Planning Application Ref: **A/23/18/DOC**

Location: **Broadlees, Dappers Lane, Angmering, BN16 4EN**

Description of works: Approval of matters reserved by condition imposed under A/27/16/PL relating to conditions 7-Construction Management Plan & **19-Tree Protection Measures**

TREE PROTECTION (Plan 3A)

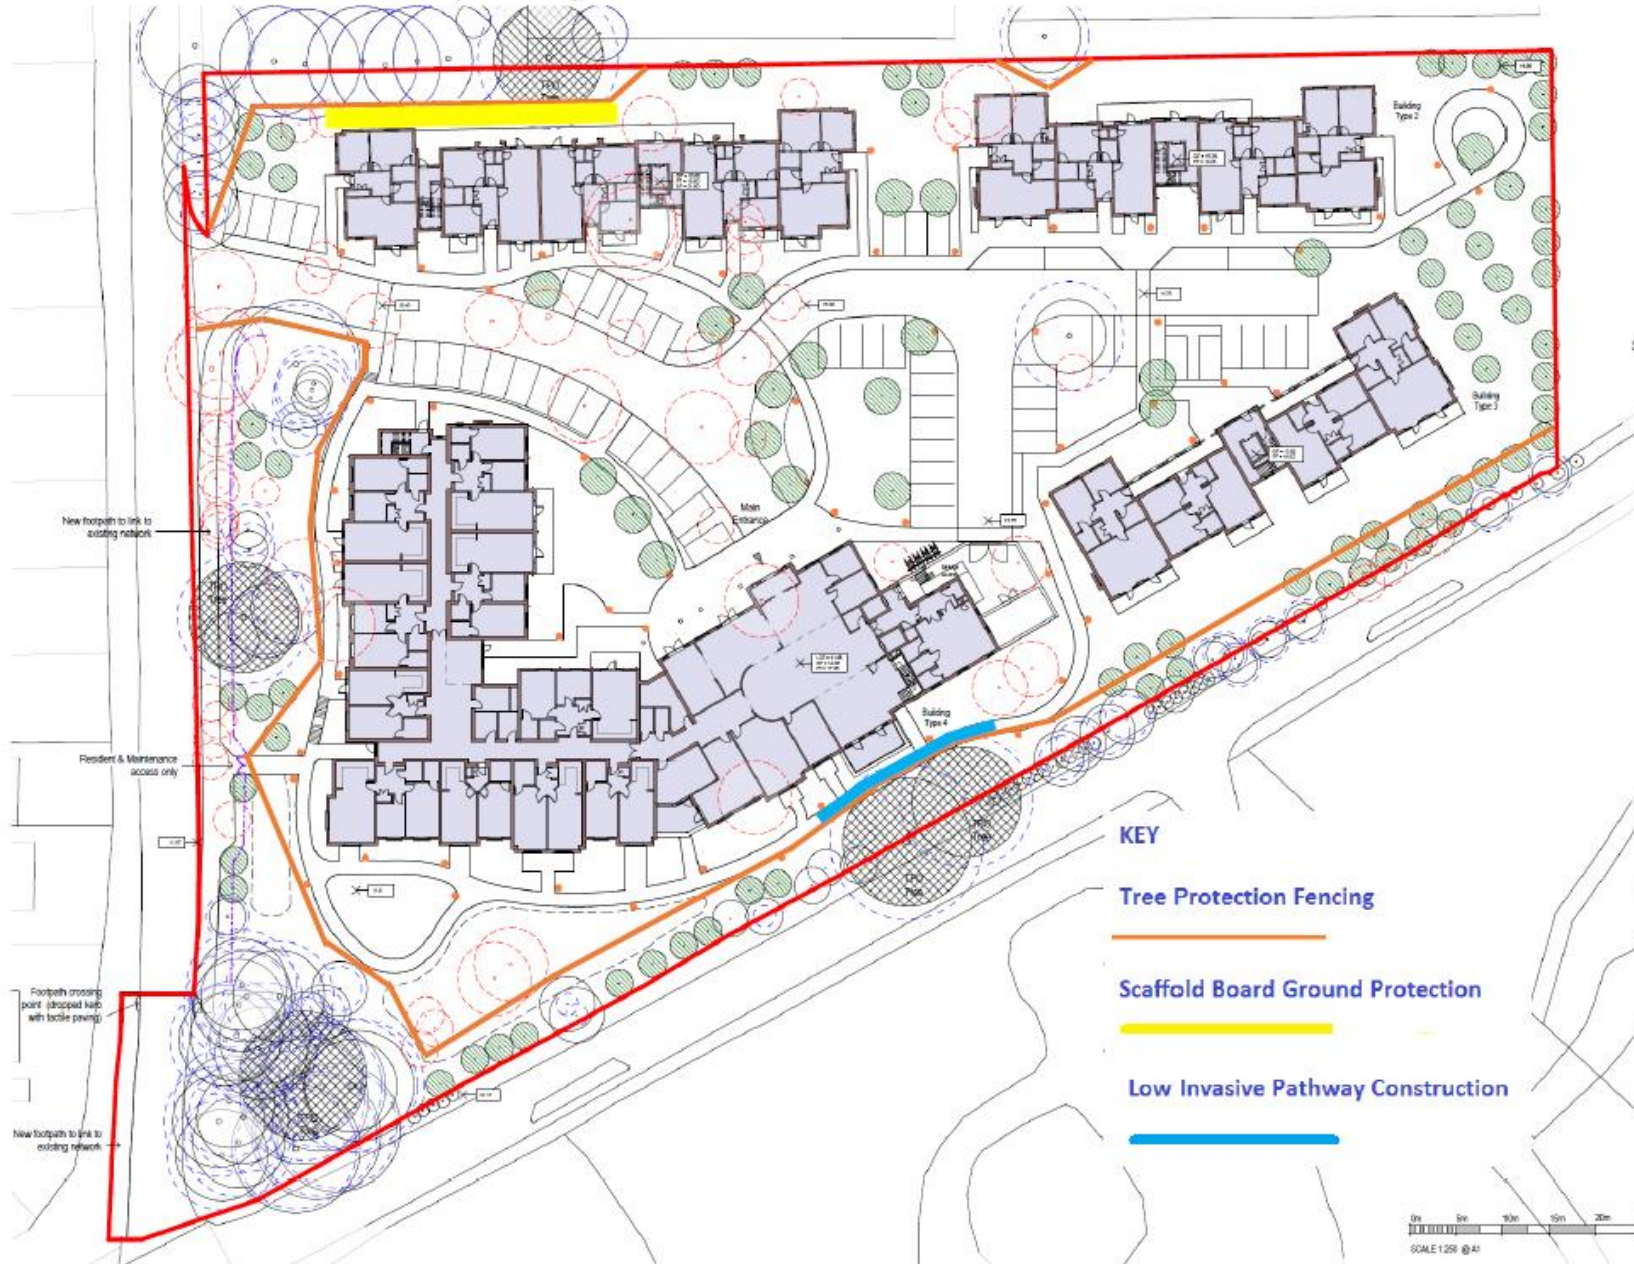
- The above plan did not include the Ground Protection Measures, as detailed on an earlier plan prepared by **Harris Irwin, Tree Protection (Plan 3a), Dwg. No.PL/01/83 Rev C, dated** and which seeks to protect significant trees during approved incursion into their root protection area (RPA).

- The vast majority of tree protective fencing was seen to be 'fit for purpose' and in accordance with the latest tree protection plan. One significant exception and anomaly were observed, as described in my last email, dated 5th September 2018.

- The few minor exceptions and anomalies I observed at the time of my last inspection have been resolved to my satisfaction (see email dated 17th September forwarded to us both, with photographs from Emma Patchell of Gillings Planning).
- I note that a second DOC application for Tree Protection Measures at this site has been submitted, which asks for the Harris Irwin plan drawing to be considered, so am now satisfied that adequate protection can be in place nearer the time of subsequent phases of development. I look forward to hearing from the applicant once the next phase of tree protection has been installed and is ready for inspection.

- **I recommend we now discharge condition 19** under this application reference.
